Addendum No. 1

RE: Contract # C204175

Forsyth County (I-5952)

I-40 From SR-1101 (Harper Road) In Clemmons To East Of
US-421/I-40 Business In Winston-Salem

TYPICAL SECTION NO. 1

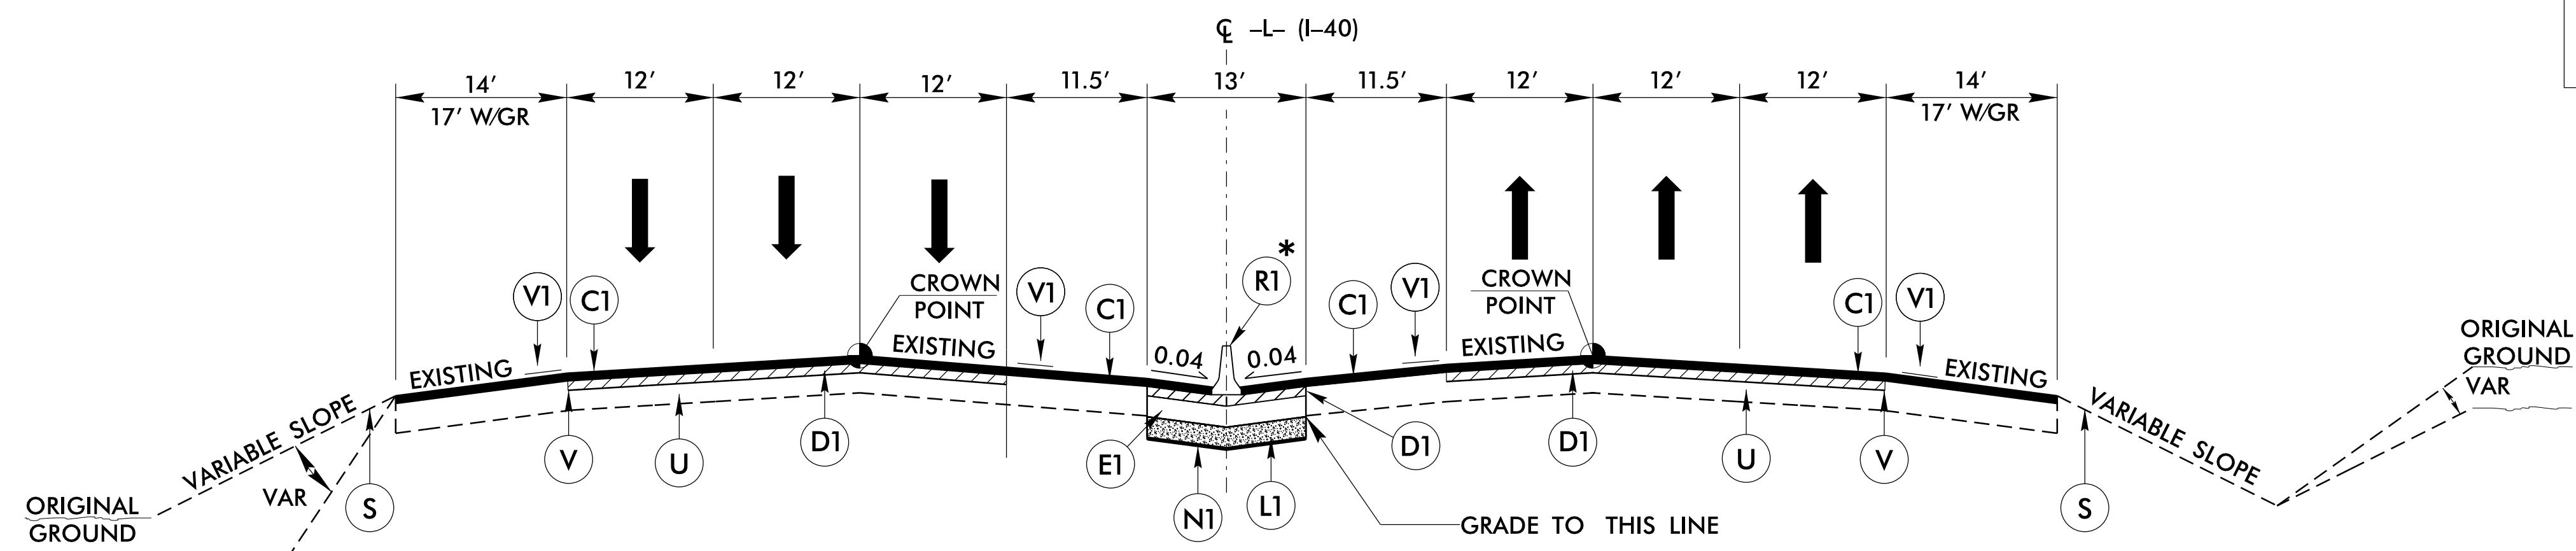
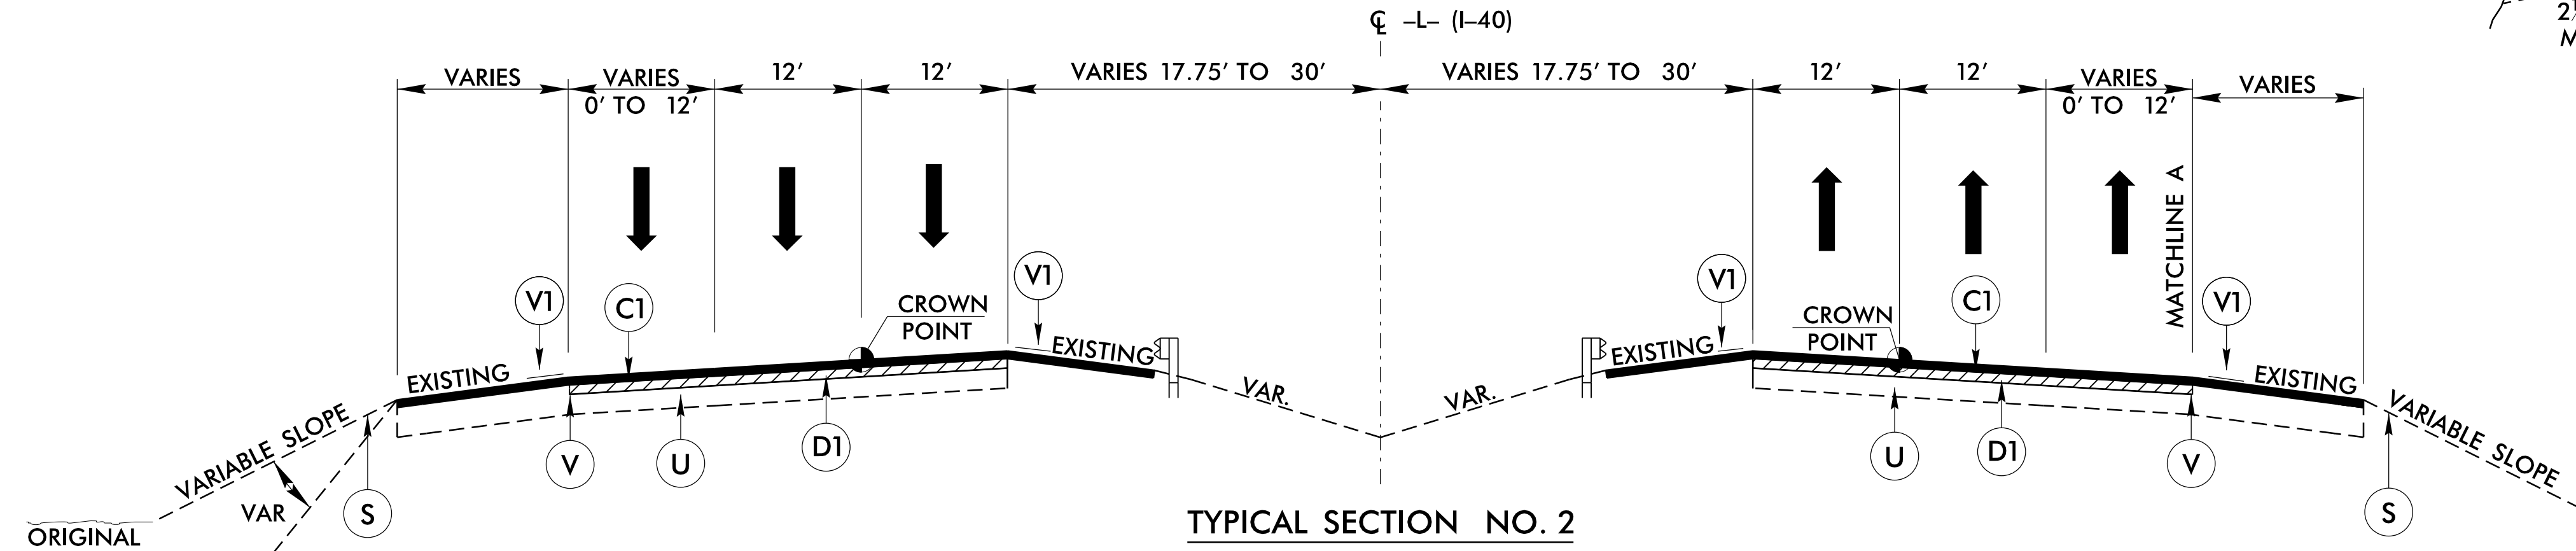
Sheet No.	Revisions
2A-1	Revised the typical section to show the Double Faced Concrete Median Barrier keyed into the asphalt layers
New 2C-3 and 2C-4	New sheets to include details about the median hazard protection for existing overhead sign location and existing bridge pier location
